Application Ref:	3/2025/0335			 Ribble Valley Borough Council www.ribblevalley.gov.uk
Date Inspected:	N/A	Site Notice:	N/A	
Officer:	LW			
DELEGATED ITEM FILE REPORT:				PERMISSION REQUIRED

Development Description:	Prior approval for proposed single storey rear extension under Part 1 Class A of the GPDO 4.15m long, 3.75m high (max) and 2.4m high to eaves. Demolition of existing conservatory and access to the rear and side garden included.
Site Address/Location:	19 Pendle View, Brockhall Village, Old Langho, BB6 8AT.

Title: Proposed Elevations

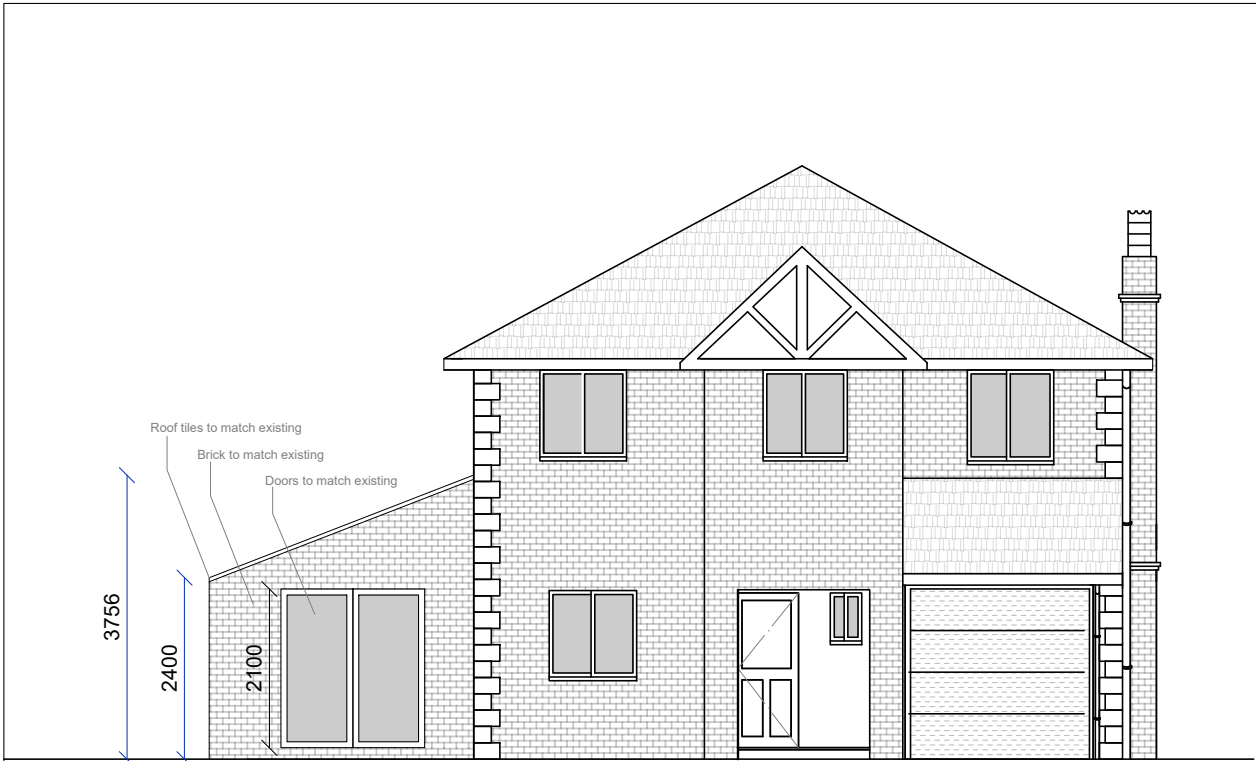
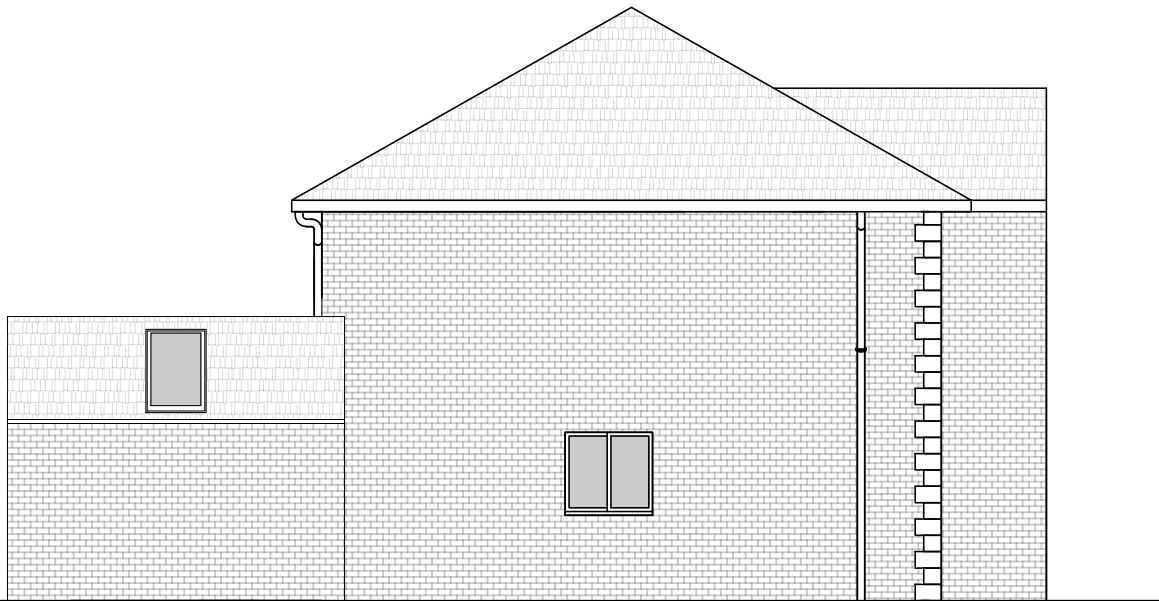
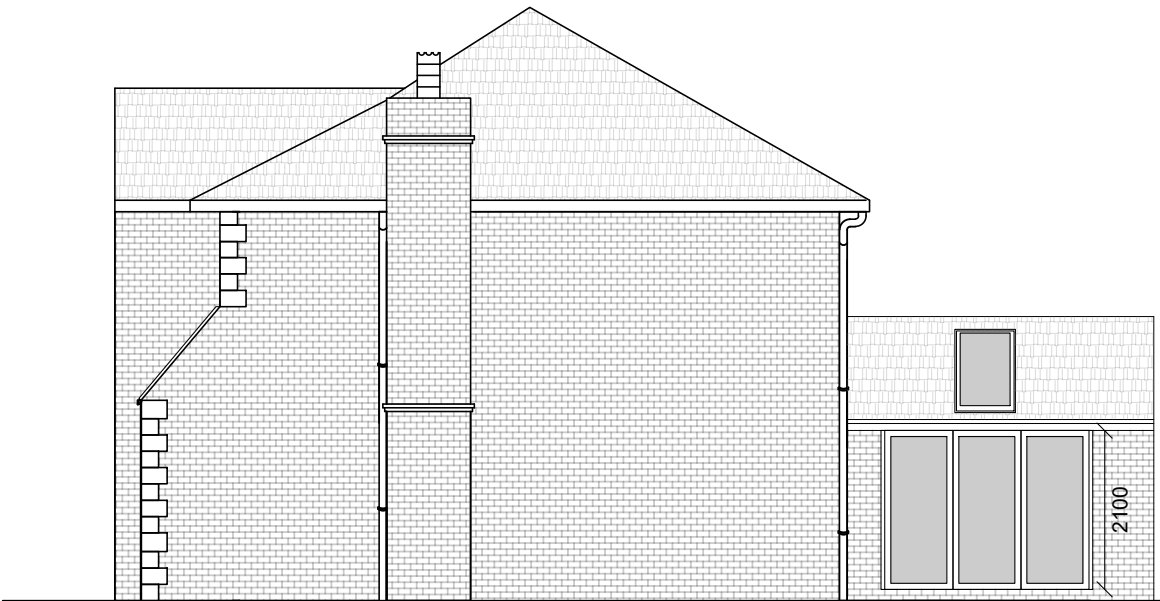
The dwellinghouse is not on article 2(3) land nor on a site of special scientific interest. The application property is a detached dwelling and the proposed extension would extend beyond the rear wall of the original property by 4.2m and would not exceed 4m in height. The proposal therefore complies with the above.

The proposed extension would be within 2m of the boundary of the curtilage; however, the height of the eaves would not exceed 3m.

The proposed development would extend beyond the side elevation of the dwellinghouse. Whilst the extension would not exceed 4m in height or have more than a single storey, the total width of the proposal would measure 7.04m, which would exceed the width of the original dwellinghouse (8.6m) by more than 50%. The proposal therefore fails to comply with above.

On the basis of the above, the proposed extension would fail to meet the requirements of criterion (j) of Schedule 2 Part 1 Class A of the Town and Country Planning (General Permitted Development) (England) Order 2015 (as amended) and therefore does not fall to be permitted development in the first instance.
